Our Ref: A/88/17/L

Application for listed building consent for a single storey rear extension under pitched roof

The Old Cottage Station Road Angmering

PROPOSED ELEVATION 1:50

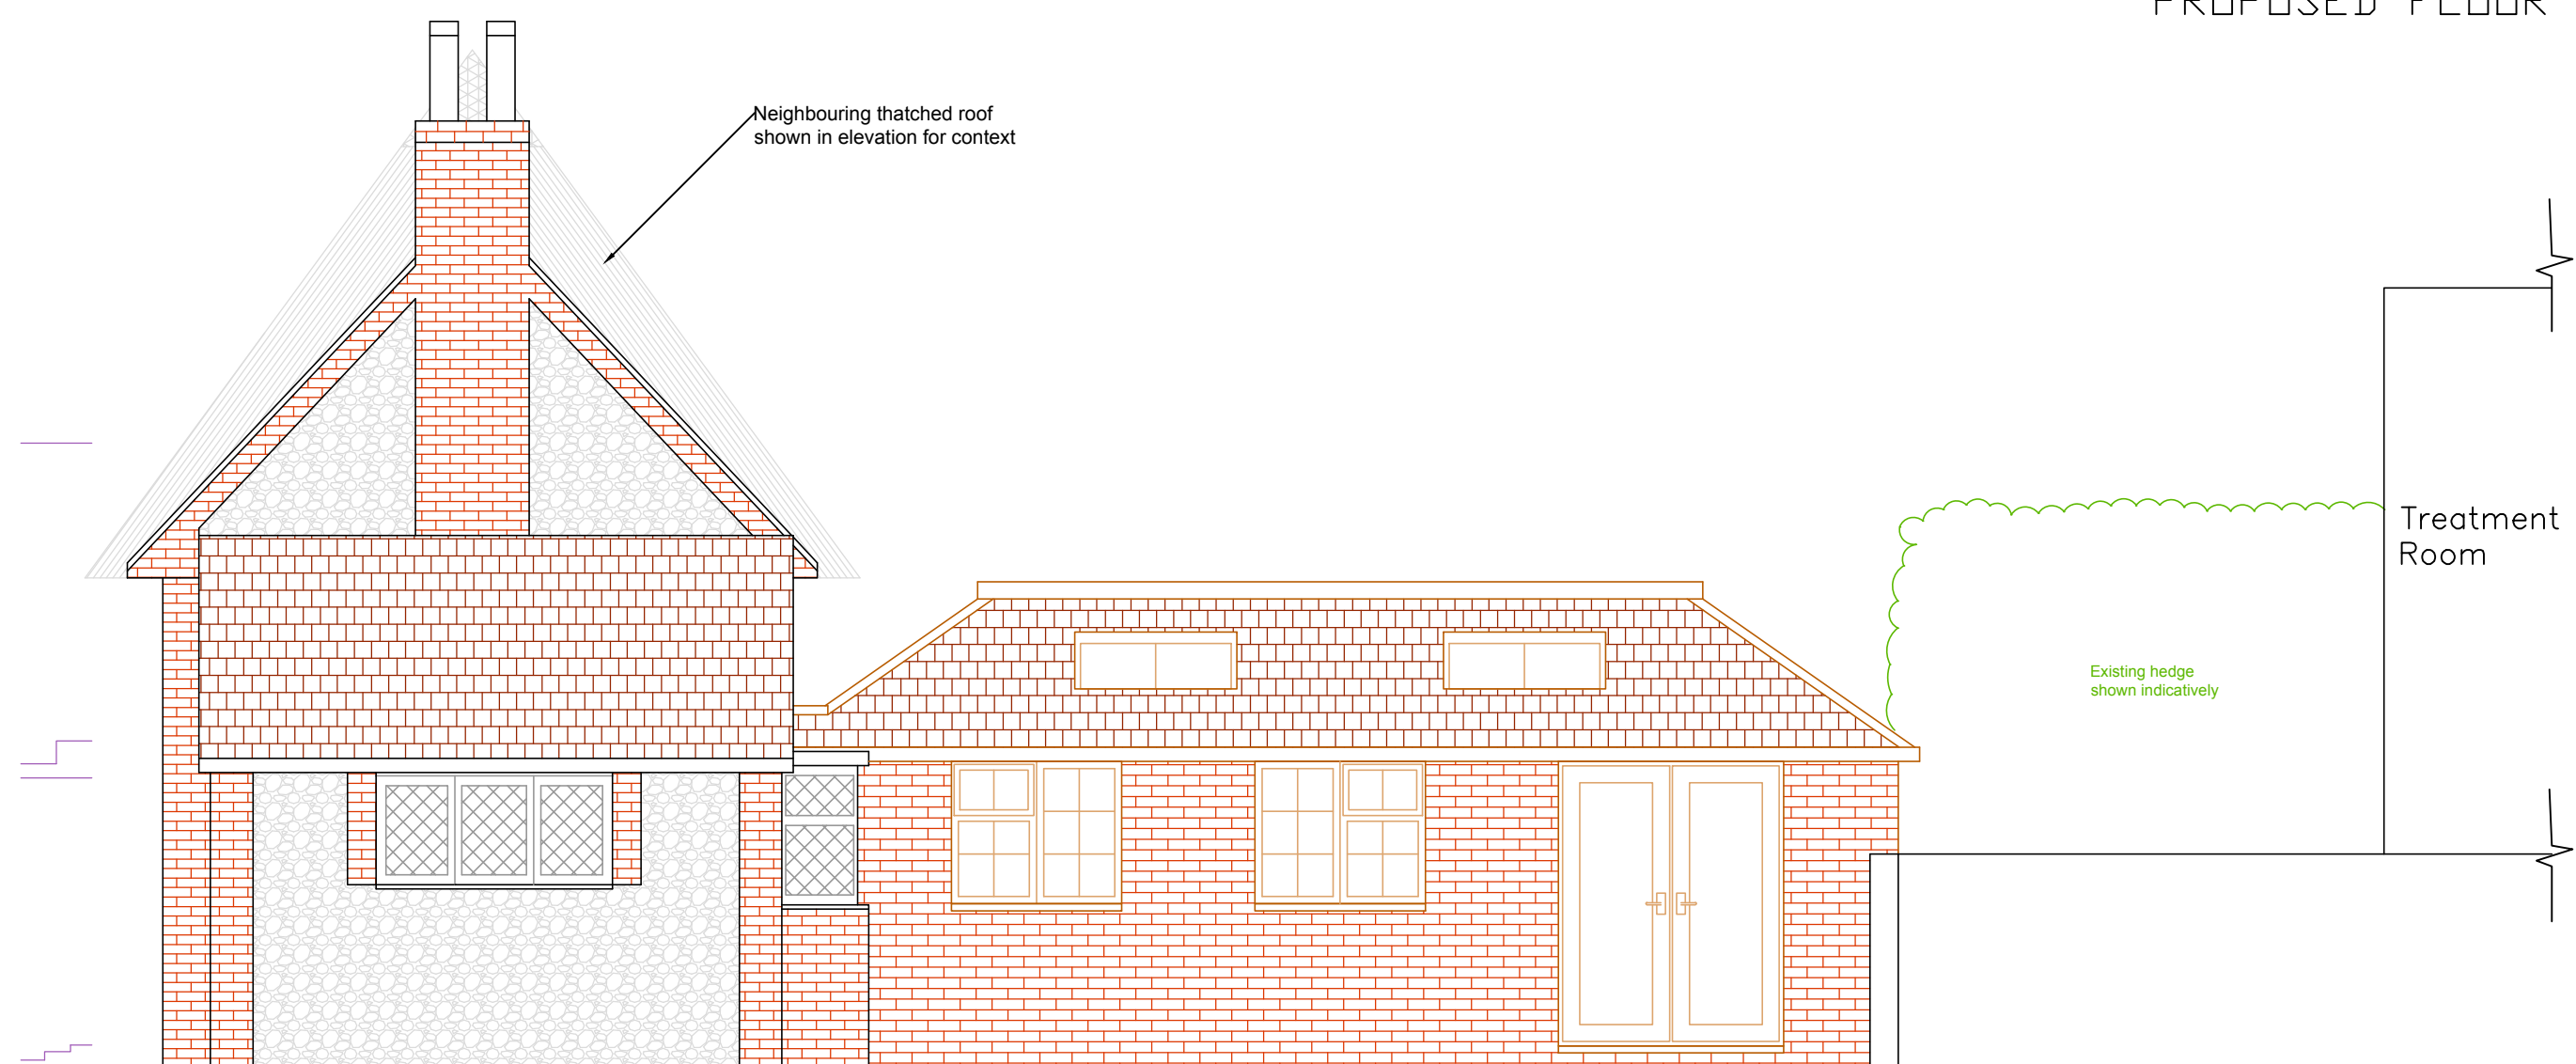
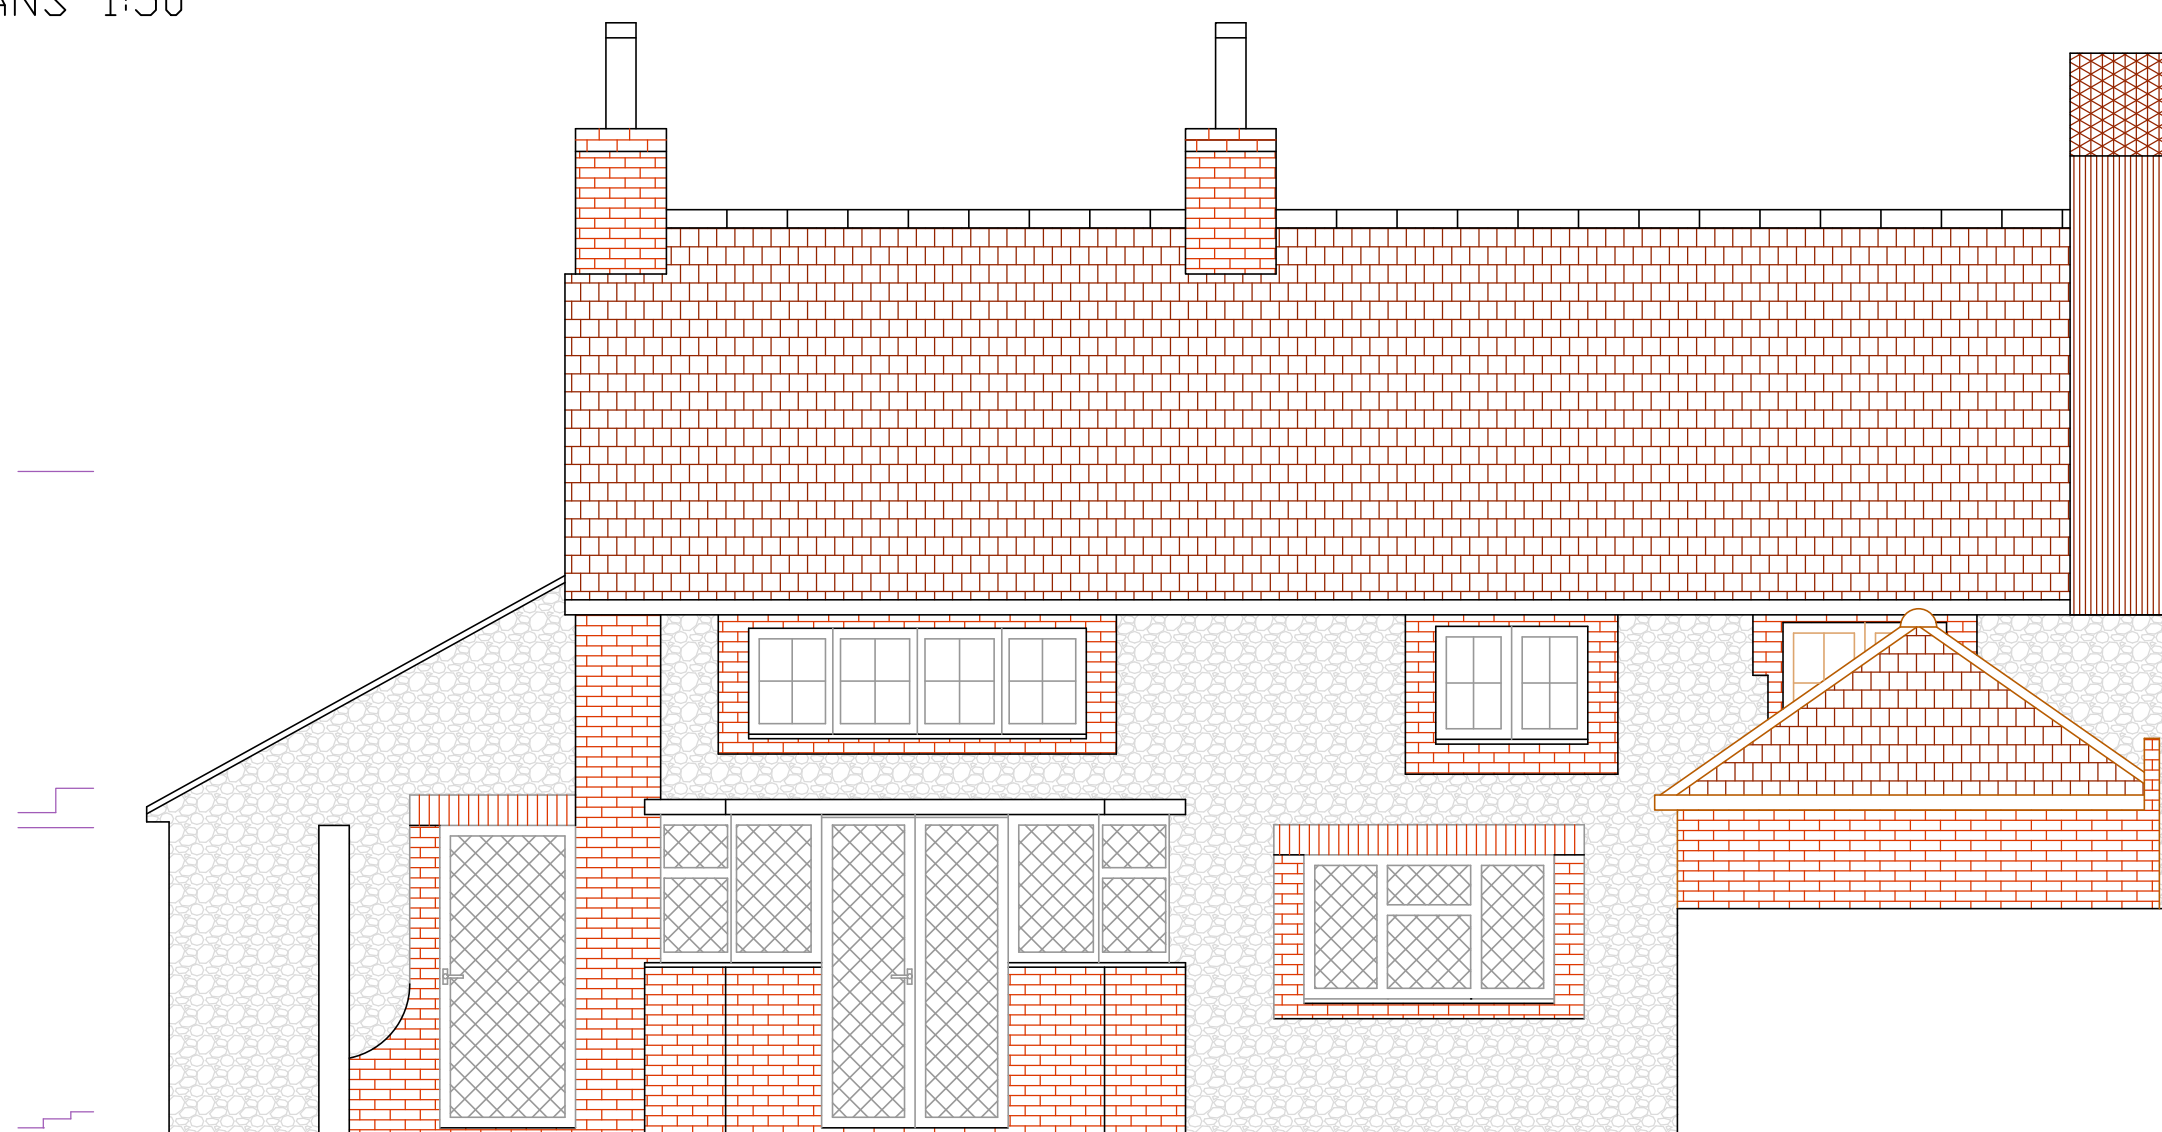
Design and appearance: The pitched roof is out of character with both the Old Cottage and the adjoining Old Mill House.

Visual Impact: It is intrusive and will completely change the appearance of the back of the cottage as well as block open views from the upstairs of the adjoining property.

Daylight/Sunlight: The height of the proposed roof will overshadow and significantly reduce light into the living room of adjoining property
